Recommendation Report for Planning Permission for Works or Extension to a Dwelling

REF NO: AW/217/21/HH

LOCATION: 11 Chawkmare Coppice  
Aldwick  
PO21 3BU

PROPOSAL: Extension to existing detached garage

Drawn by: MJW
DWG No: CC.PL002
REV No:
Date: JUNE 2021
A3 - 1:100

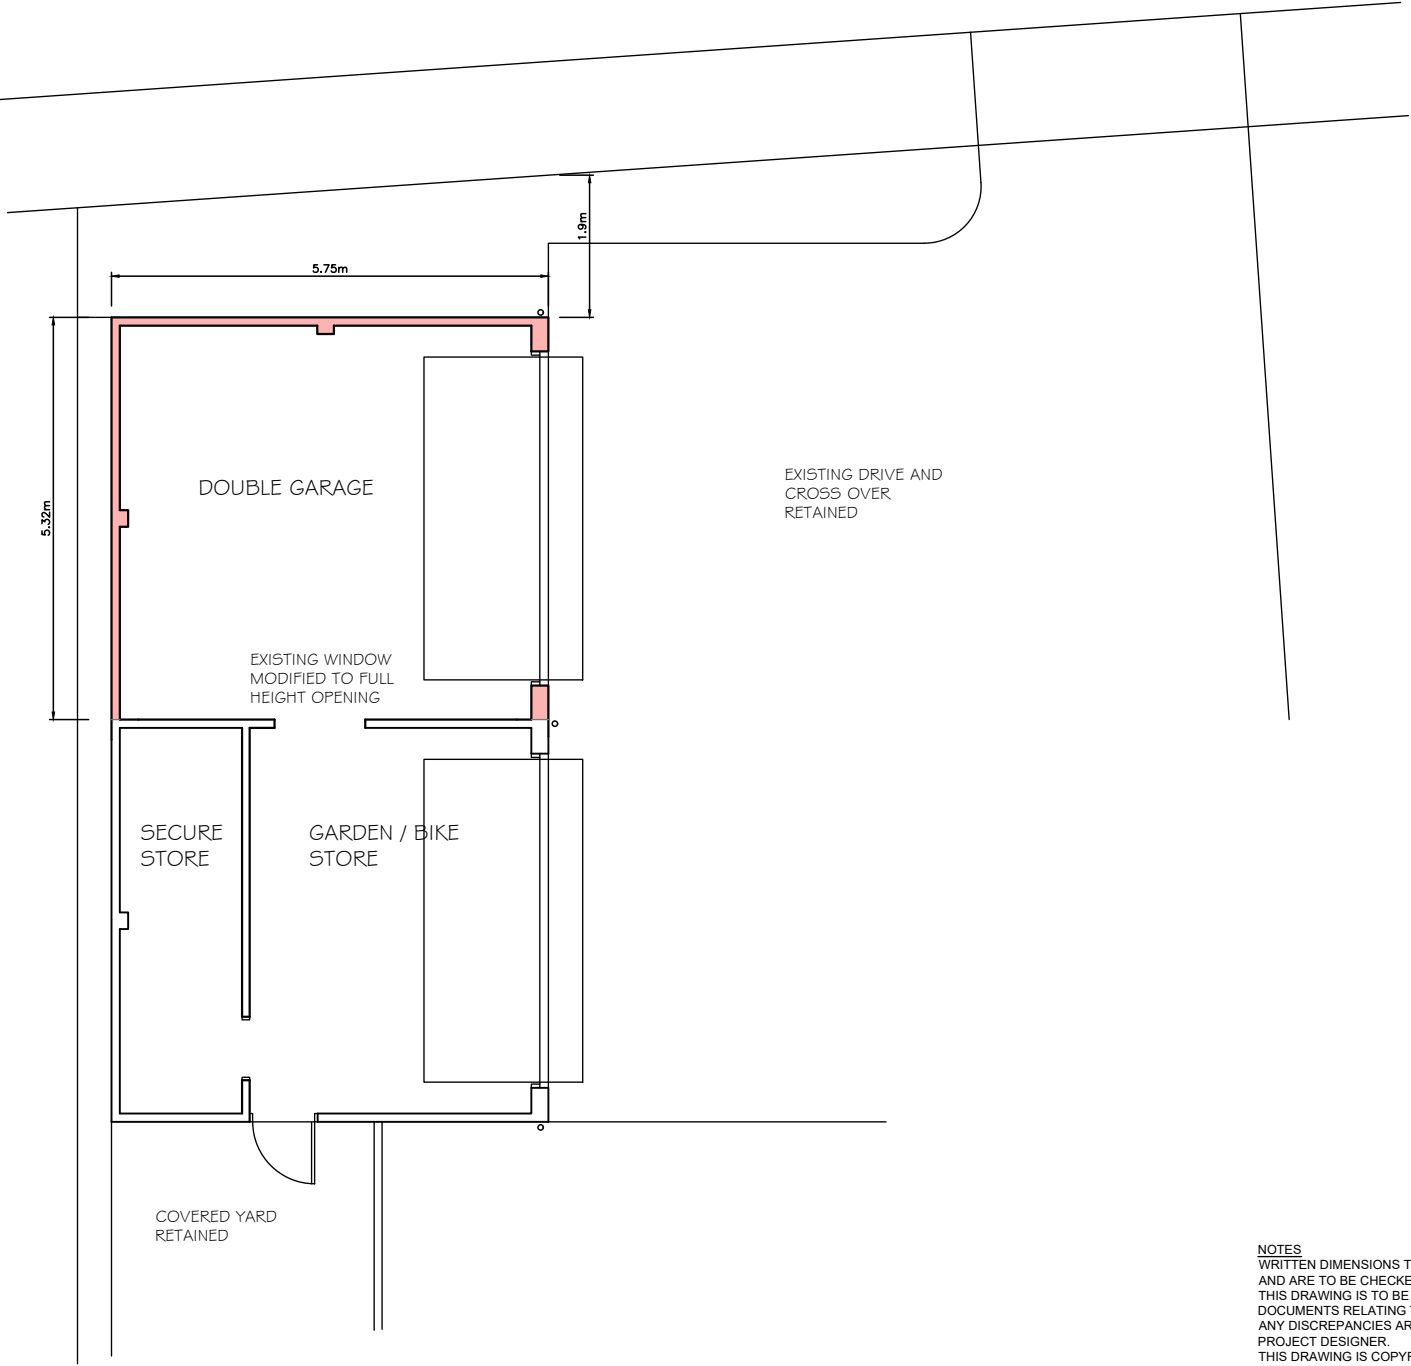
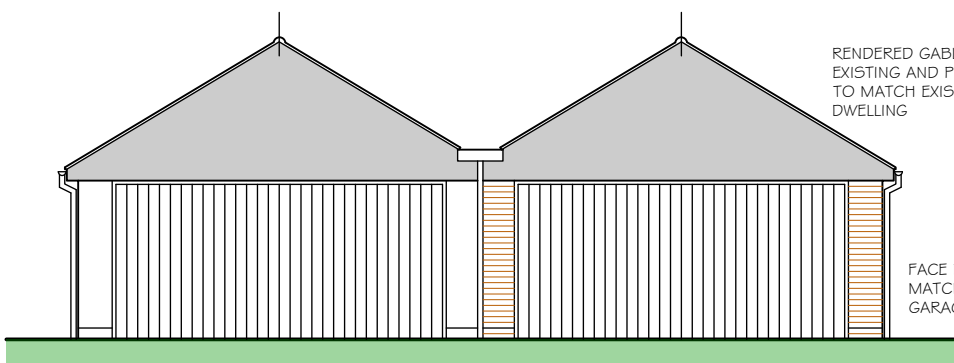
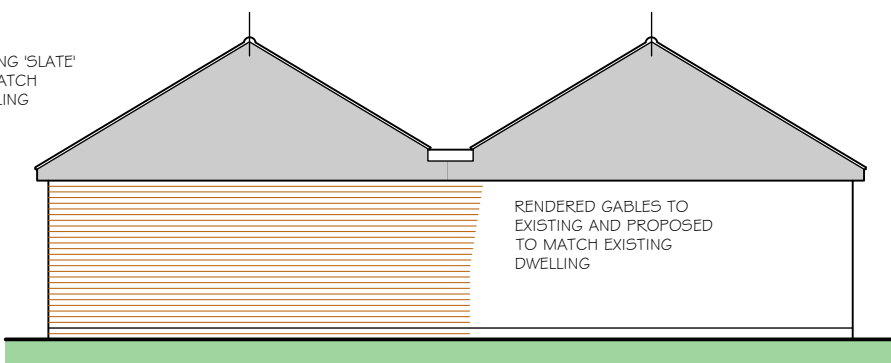
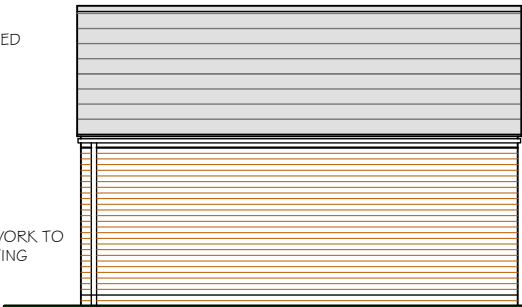
The extension of the garage has been design to be in keeping with the existing structure with materials to match, a matching eaves and ridge lines and proportions similar to the existing.

Although further forward in the street scene its identical image is not felt to be visual dominant and therefore accords with policy. Detached garages located within the front gardens are common to the street.

Having regards to the 45-degree rule the existing garage on site already conflicts with this rule. The addition of an extension to the front of the existing is not expected to make the situation worse, especially as it is located 10m away from the front of the neighbouring dwelling.

Its is not considered to overbear any neighbouring properties and does not include any new windows, therefore there are no overlooking considerations.
